UNSW TETB PROJECT

ACCESS REVIEW

Morris-Goding Accessibility Consulting

3rd December 2009

Level One

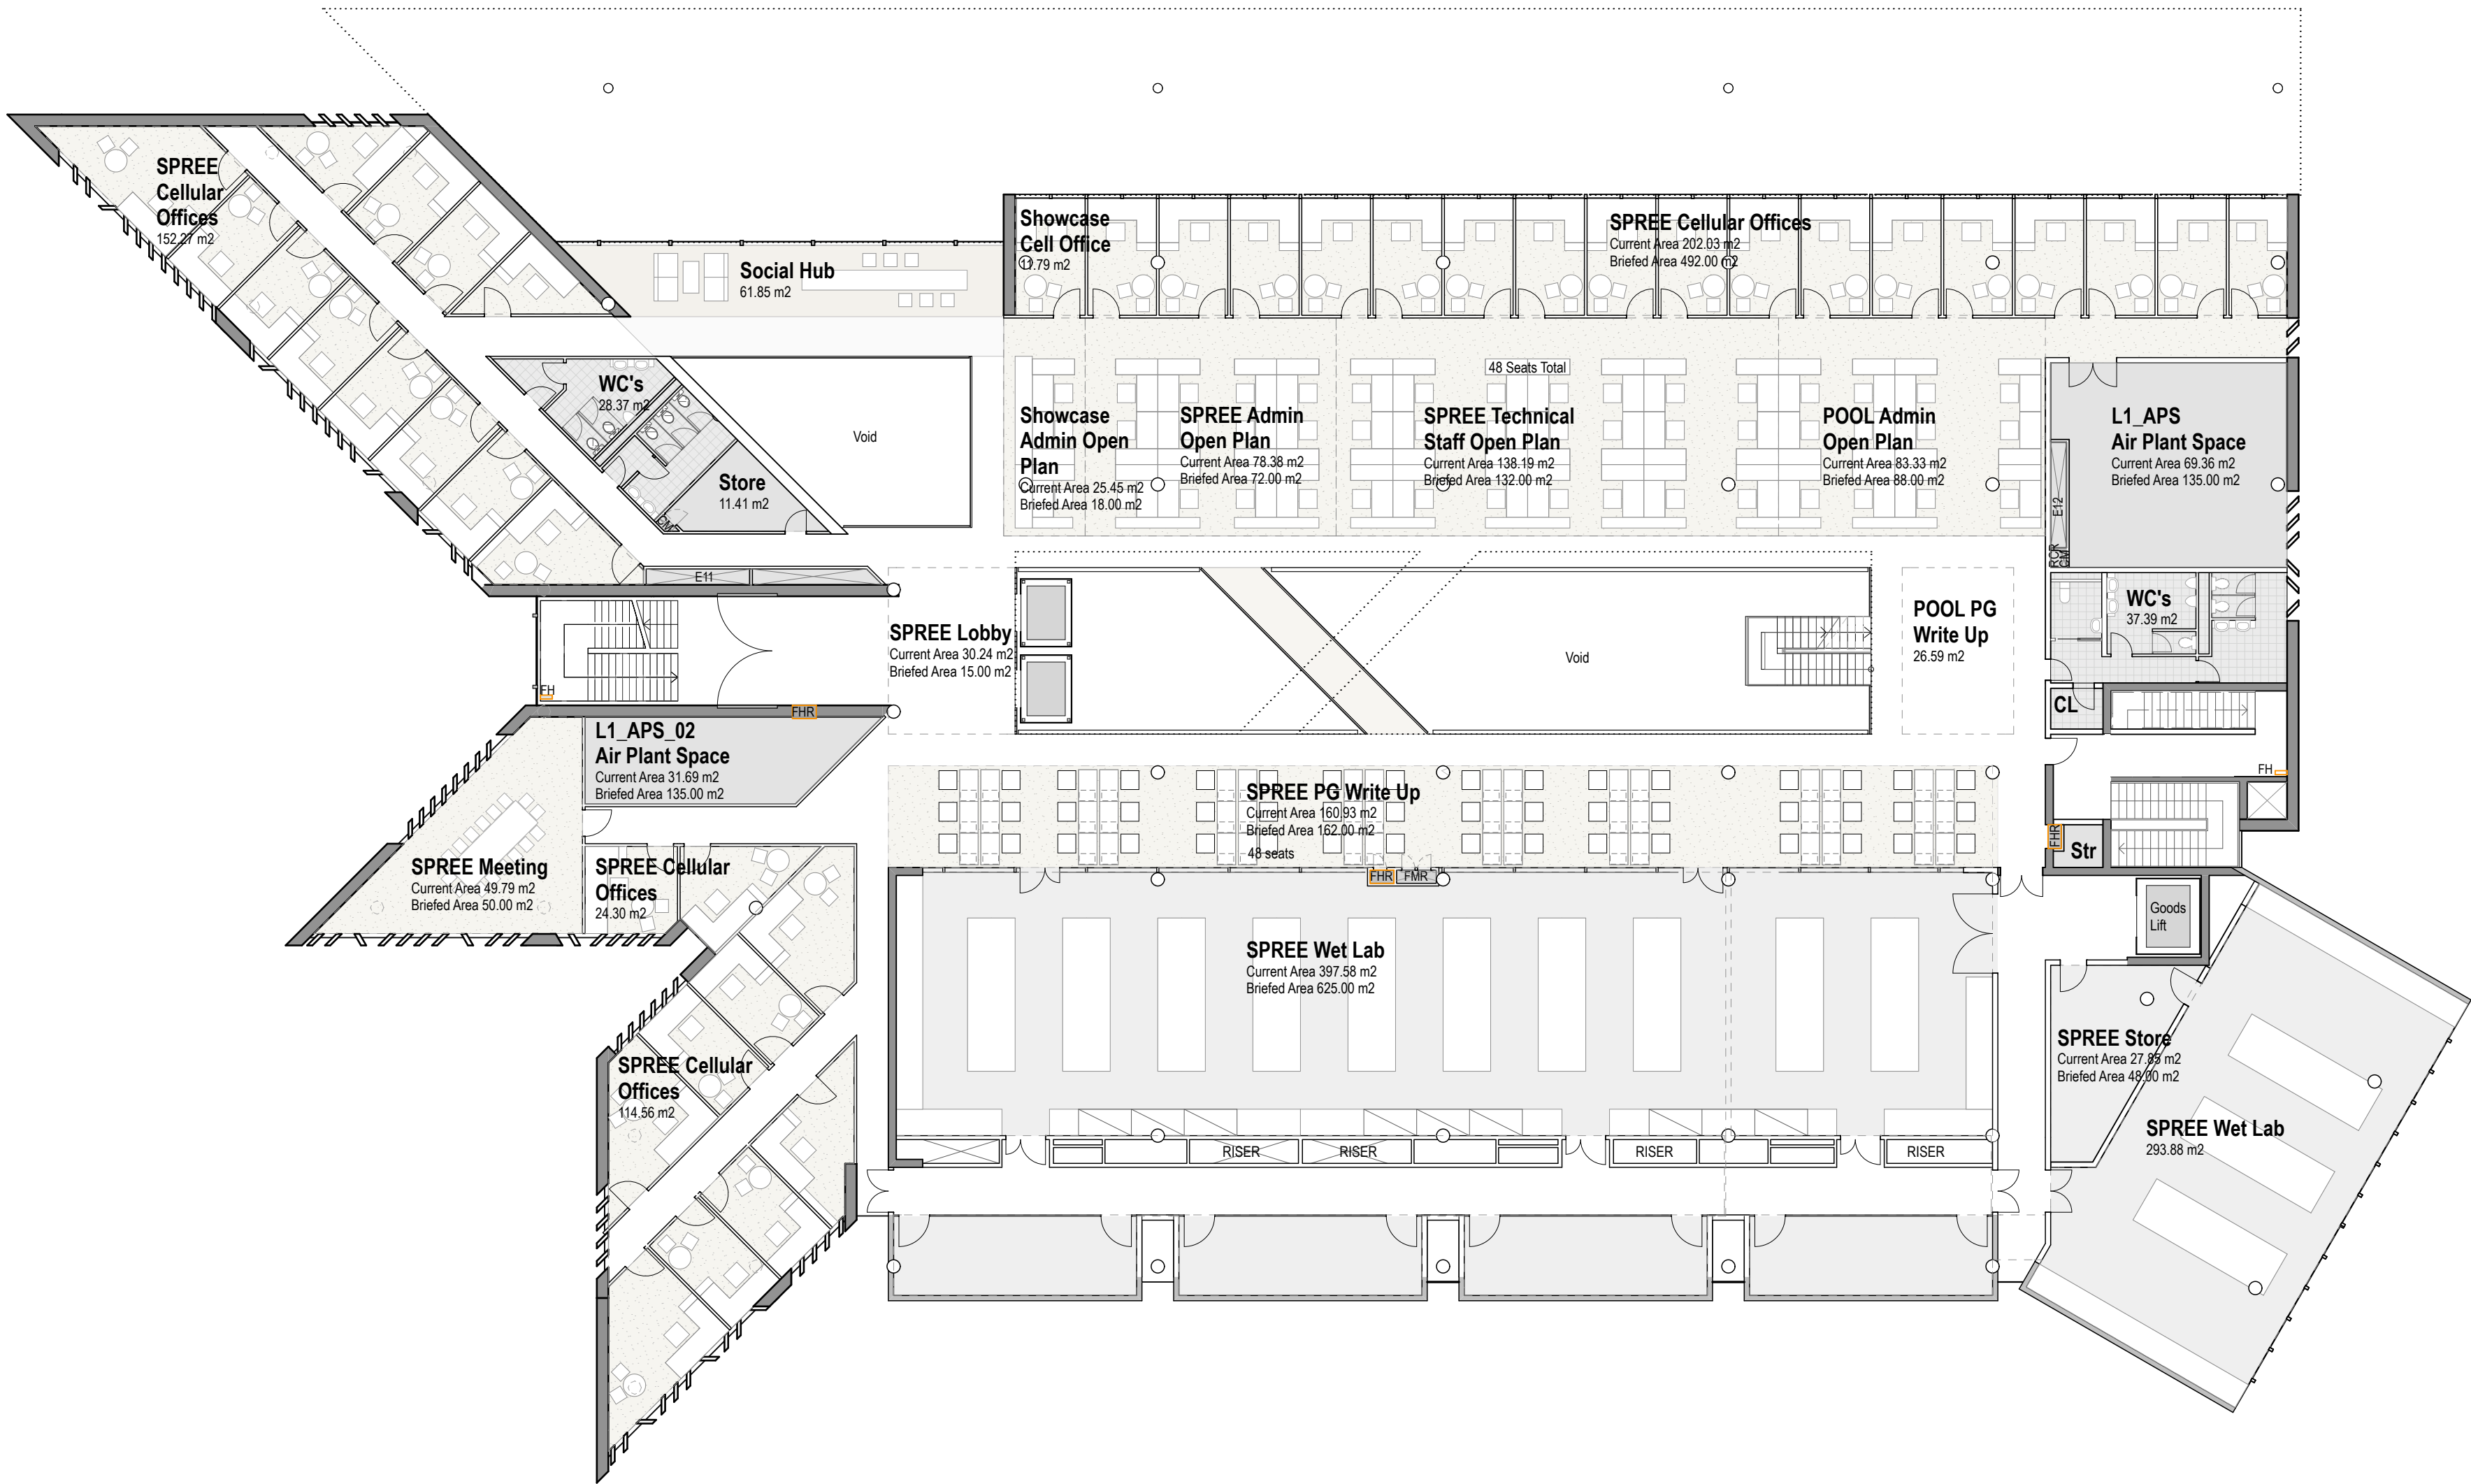
- (i) Consider the corridor ends (western side floors 1, 2 & 3) have a 1550mm width x 2070mm length to allow wheelchair user to turn 180 degrees in accordance with draft DDA Access Code.

There are two sets of WC facilities (male & female) located on floors 1, 2 & 3. There is an accessible WC located on each floor (1, 2 & 3) adjacent to the eastern WC facilities. Each accessible WC's has 2000mm (W) x 2500mm (L) internal dimensions, compliant with AS1428.1. The accessible WCs appear to have 800mm clear width sliding doors with no latch side clearances (external/internal).

- (i) At a minimum, ensure all accessible WCs to have 2500mm (L) x 1600mm (W) internal dimensions. This will allow for a 1600mm x 2000mm circulation space around the pan, compliant with AS1428.1. The washbasin can encroach into the circulation space of the pan by no more than 100mm (max), compliant with AS1428.1 and BCA part D3.
- (ii) Consideration is needed for accessible WCs to comply with AS1428.2 and draft DDA Access Code. Ensure there is 2300mm x 1900mm circulation space around the pan. The washbasin is to sit outside the circulation space of the pan.
